**BEFORE the HEARING EXAMINER for the
CITY of MERCER ISLAND**

FILE NUMBERS: CAO15-001 & VAR18-002

TYPE OF CASE: Consolidated: 1) Critical Areas Reasonable Use Exception to construct a single-family residence and associated improvements within a regulated wetland and required wetland and stream buffers; and 2) Variance from the setback requirement from an access easement

EXAMINER DECISION: REMAND

TITLE AND TESC PLAN
5637 MERCER WAY
MI TREEHOUSE, LLC
11030 SE 30TH ST
BELLEVUE, WA 98004

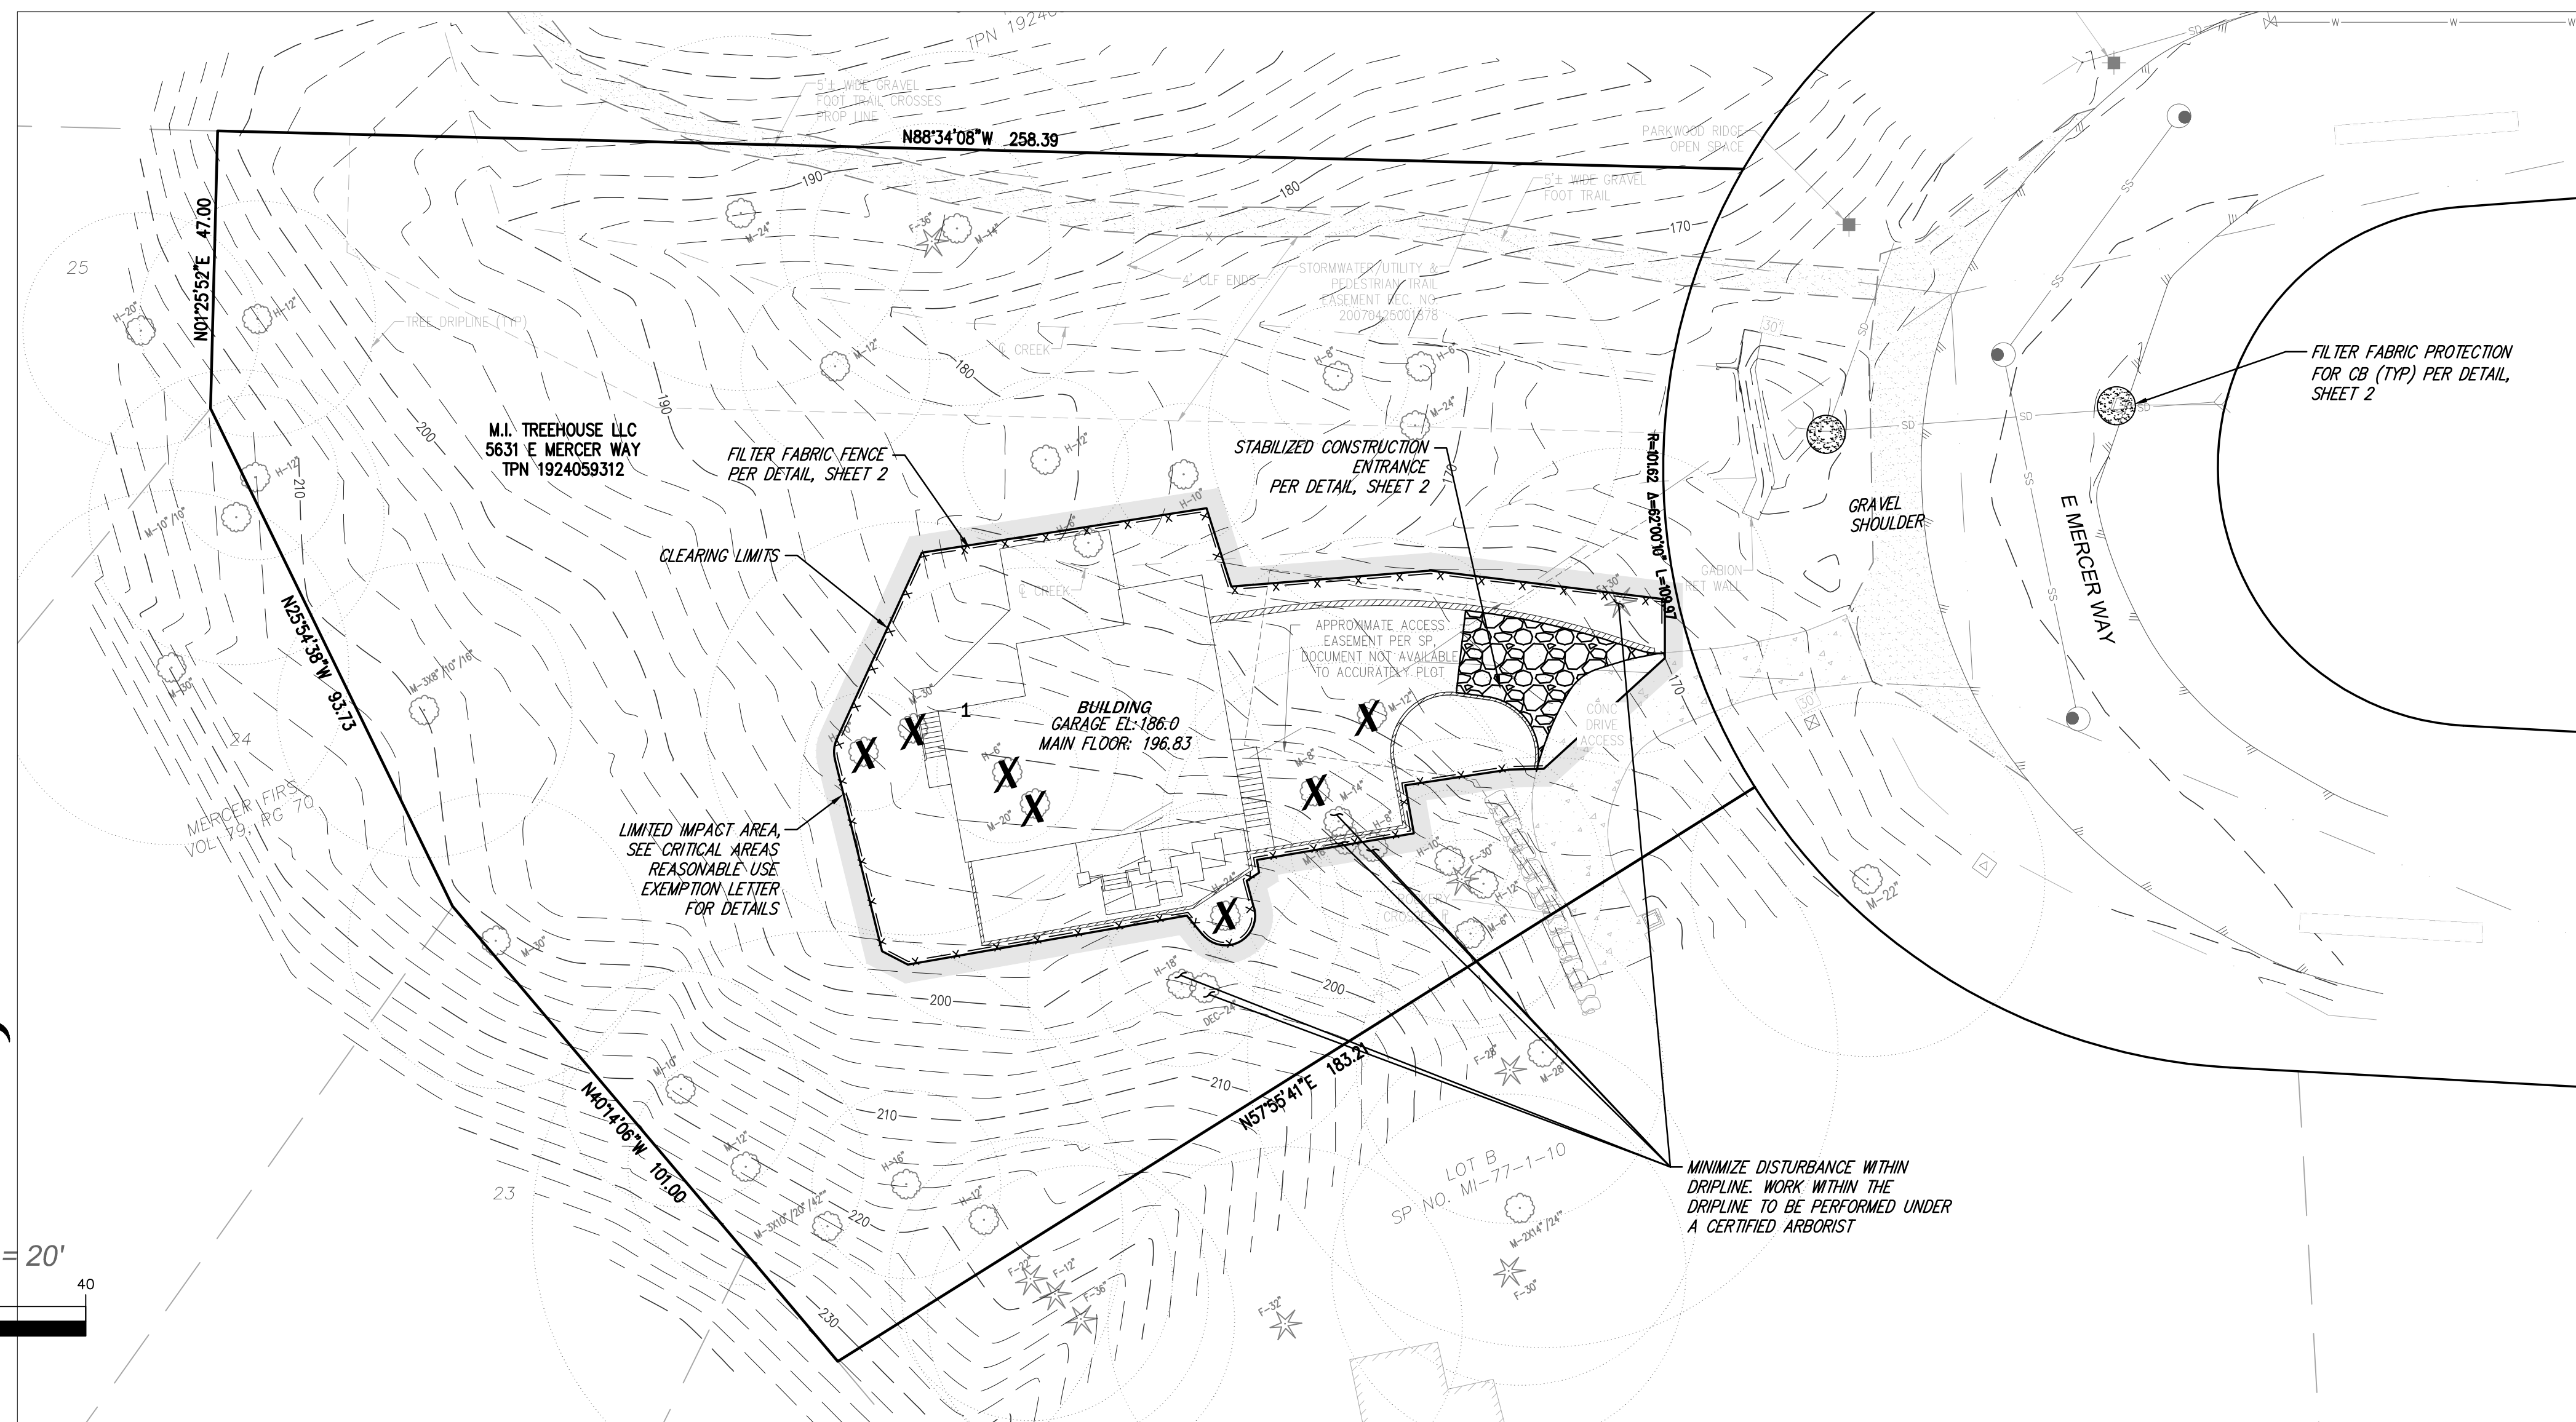
⁶ The west property line segment call-out lengths on the currently proposed site plan (Exhibit 38) match the call-out segment lengths on the original short plat that created Parcel 9312 (Exhibit 39). However, the line segments as drafted on Exhibit 38 do not match the call-out lengths: The north segment which should be 47 feet is drawn as 57 feet; the middle segment which should be 94 feet is drawn as 65 feet; and the south segment which should be 101 feet is drawn as 119 feet. The total length is about the same, but the segment lengths and resulting angles are inaccurate. Thus, it appears that Parcel 9312's shape is inaccurately presented on Exhibit 38.

Neither the off-site northern or western steep slopes are depicted on the proposed site plan, Exhibit 38.

⁸ The inference from the contour lines on Exhibit 38 near the north property line that the parcel to the north exhibits gentle slopes is most likely quite mis-leading. Exhibit 23, Appendix A, PDF pp. 6 & 7 strongly suggests that the slope becomes significantly steeper immediately to the north.

The Fir tree referred to in Condition 2 of the *Sunrise Ridge* short plat isn't where it's supposed to be, or it may be a Maple instead of a Fir, or it may not exist.¹⁸ In fact, *Sunrise Ridge* short plat Condition 2 specifically says the Fir tree is outside of the then-proposed access easement. The tree that Summers' agents are referring to (which does not appear to be labeled as a Fir) is consistently depicted as being inside the access easement, not north of it. That merely adds another element of confusion since the short plat did not depict trees. The Examiner cannot approve a permit which would violate a condition of short subdivision approval. The Fir tree must be accurately located.

Wetland and Wetland Buffer Impact Site Plan

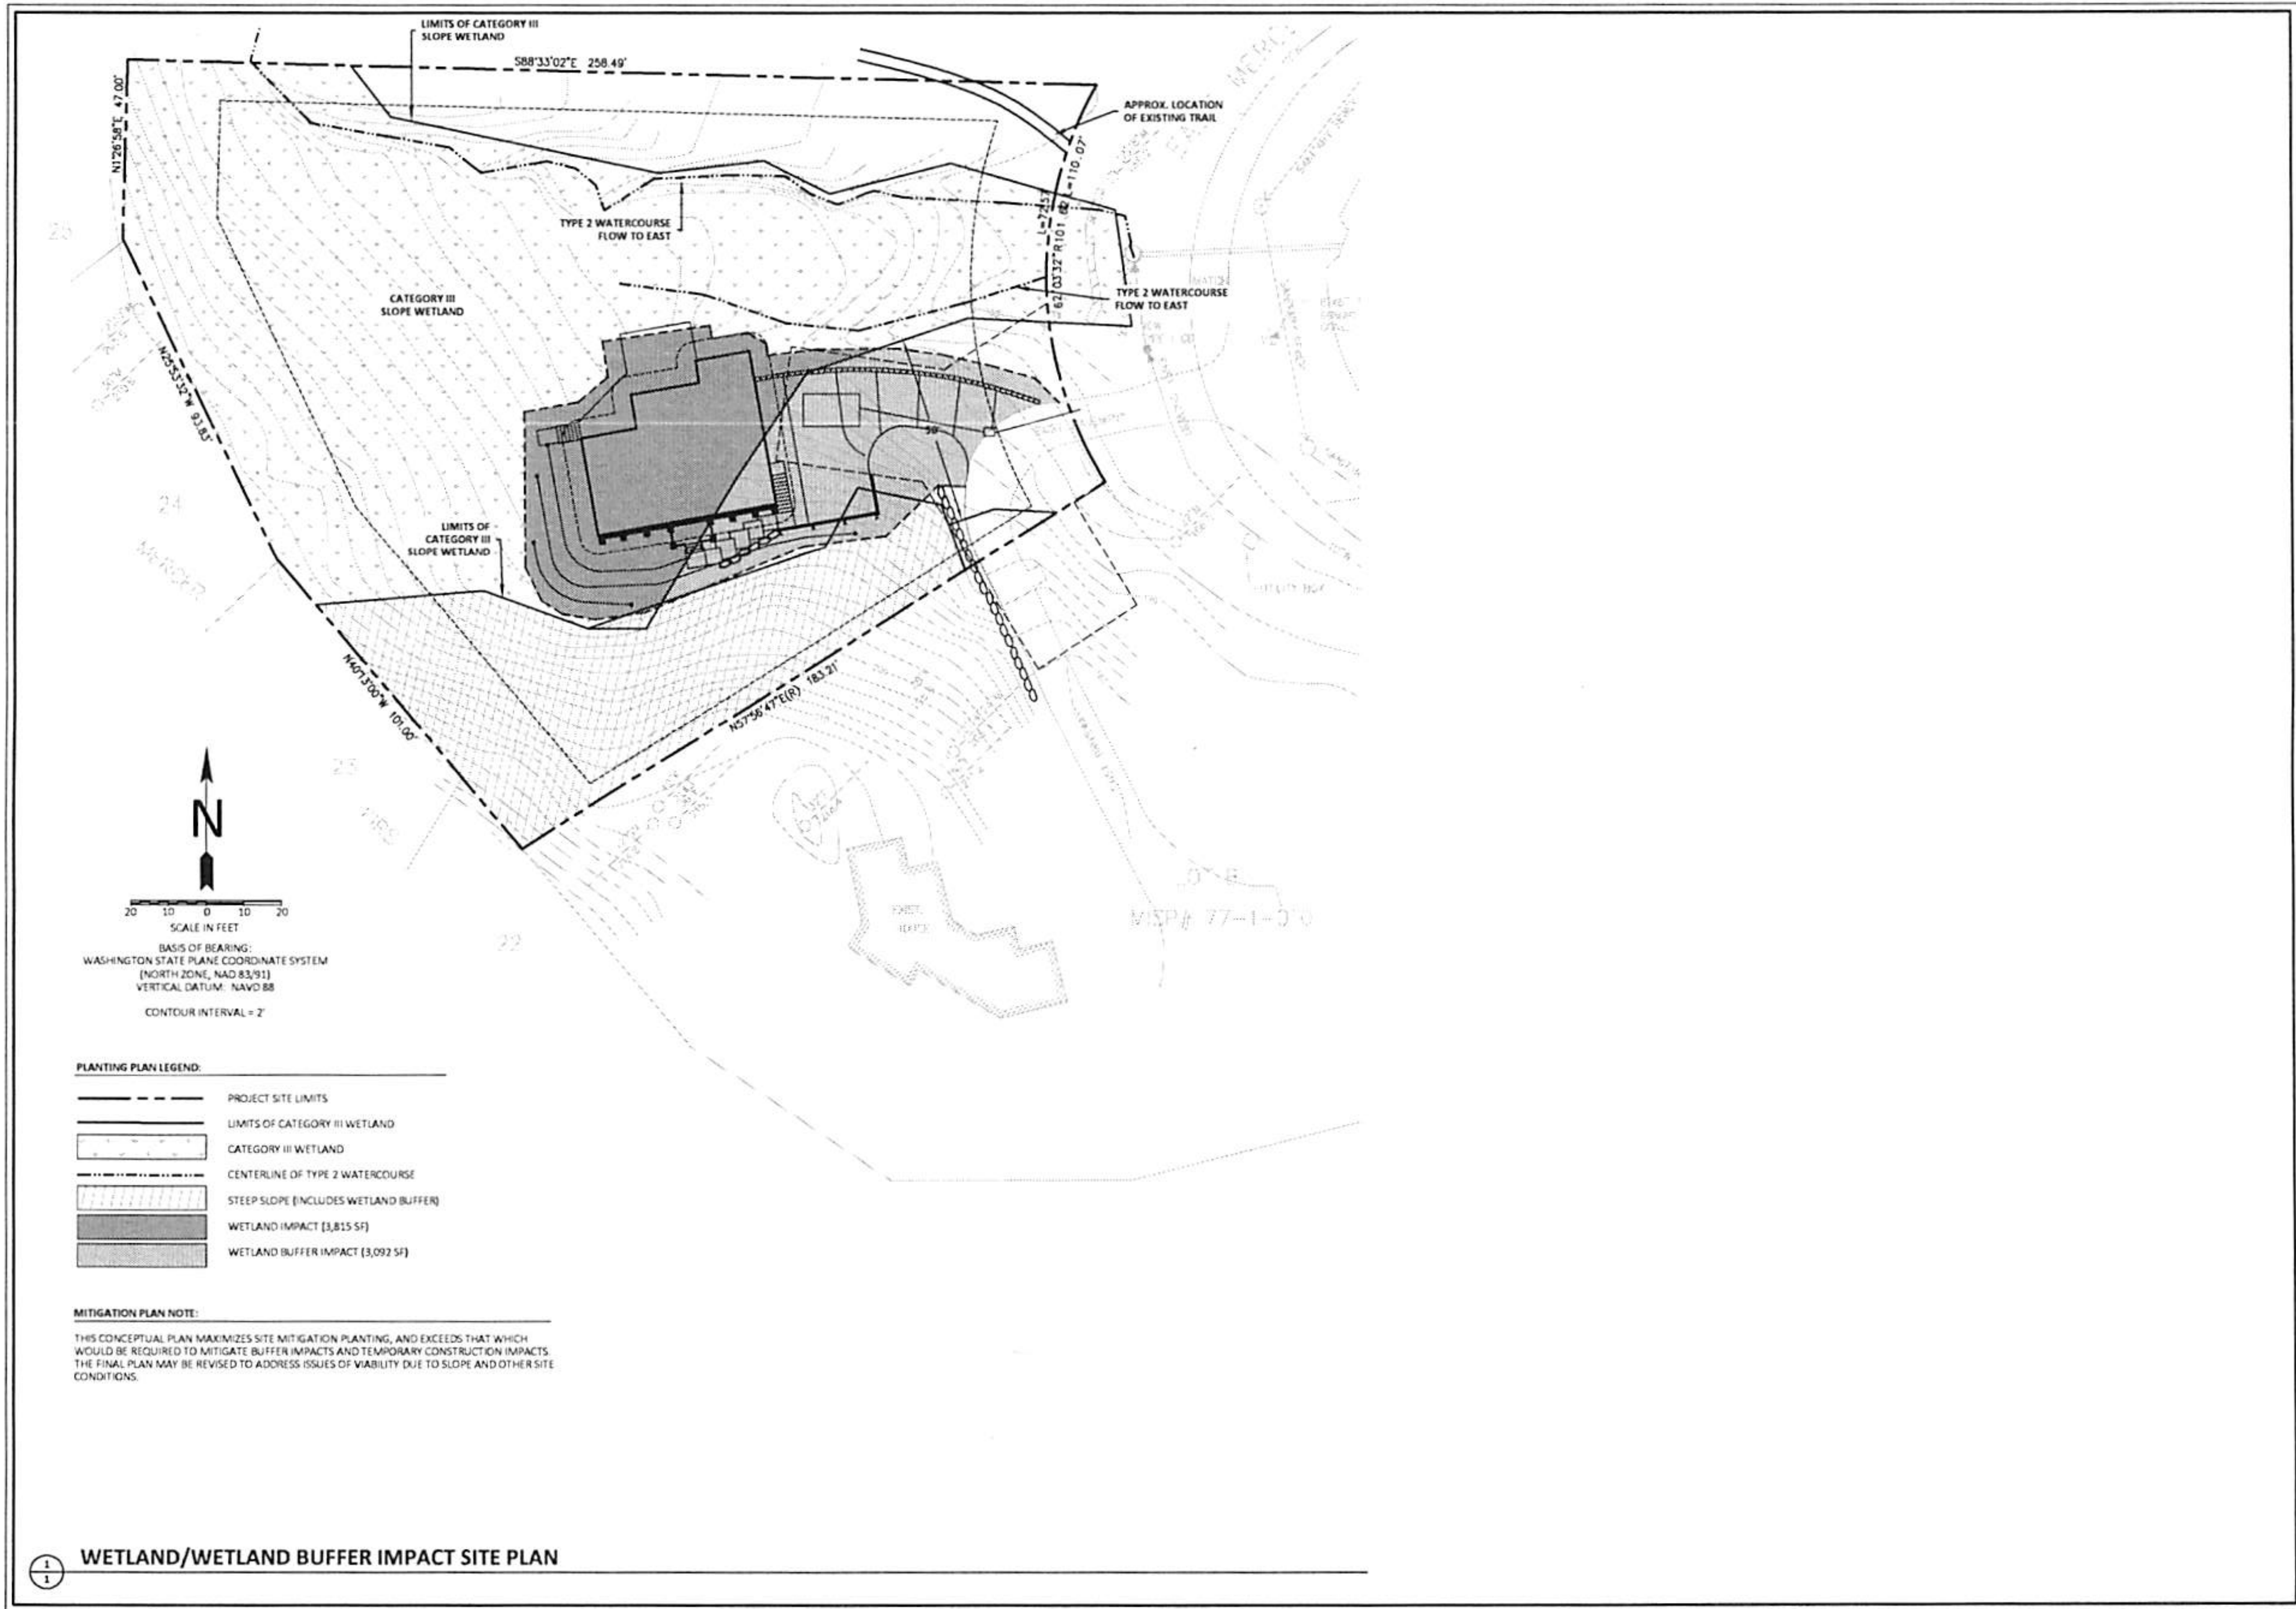
15. Stream B is depicted in various locations and with various lengths on the maps and plans contained in the record. (Exhibits 12b, PDF pp. 3 & 20¹⁰; 12c, PDF p. 7; 38; 42d, PDF p. 5) On the latest project plan (Exhibit 38) Stream B defies geographical logic: It is depicted as flowing diagonally down the shallow side wall of a small, on-site draw. Streams simply do not do that in the real world.¹¹ Streams flow down the centerline of draws or ravines, not slaunchwise down their sides. If the topography on Exhibit 38 is accurate and if Stream B were properly mapped, it would originate at or flow beneath the northeast corner of the proposed residence, depending on its length. By drawing Stream B on the side of the slope, it misses the house by about seven feet. (Exhibit 38)

Stream B appears to run diagonally down a side slope – in a geographically impossible alignment. Stream B is short on some versions of the plan, and substantially longer on others. Stream B magically ends right at the edge of the East Mercer Way right-of-way – an unlikely reality.¹⁷
